Flying Horse North Filing No. 1
Updated Traffic Impact Analysis
PCD File No. SF-18-001
(LSC #174871)
April 5, 2018

RE: Flying Horse North Filing No. 1
El Paso County, Colorado
Updated Traffic Impact Analysis
LSC #174871

N:\09611\DRAWINGS\CONSTRUCTION\109611-SI-37.dwg, 12/15/2017 7:50:41 AM, DWG To PDF.pc3

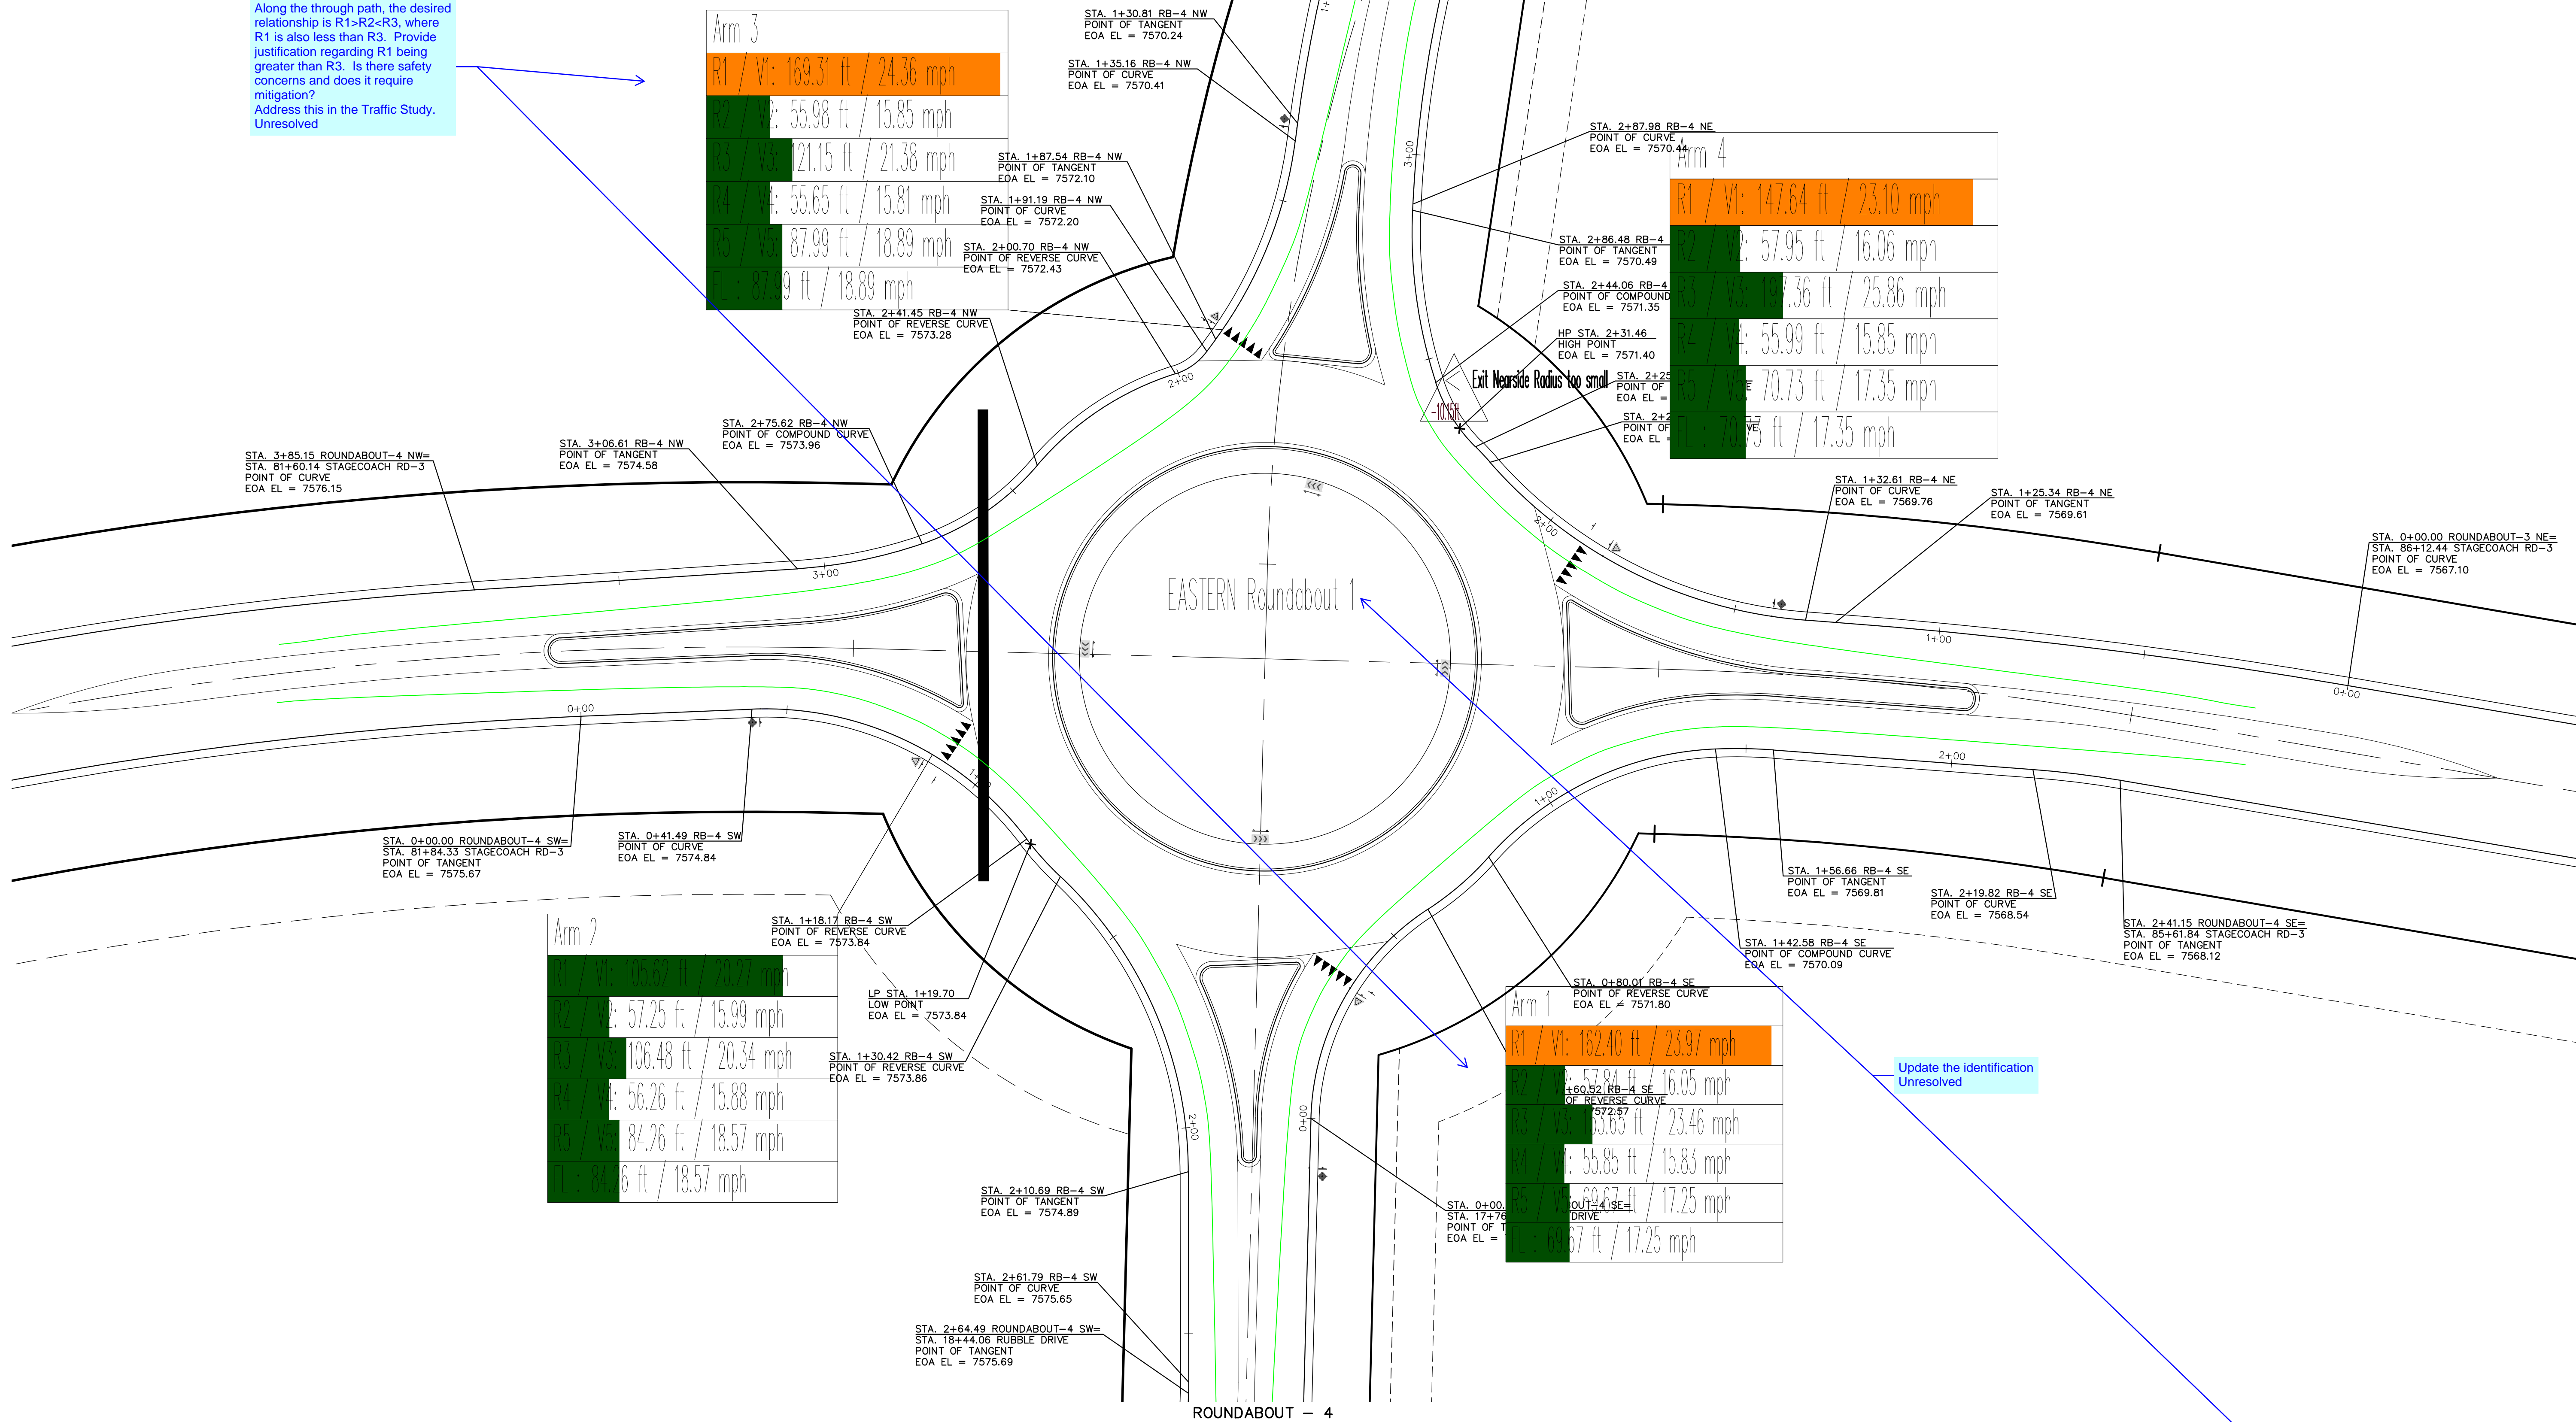
Along the through path, the desired relationship is $R1 > R2 < R3$, where $R1$ is also less than $R3$. Provide justification regarding $R1$ being greater than $R3$. Is there safety concerns and does it require mitigation? Address this in the Traffic Study. **Unresolved. This is a comment made in sheet 37 of the construction drawings.**
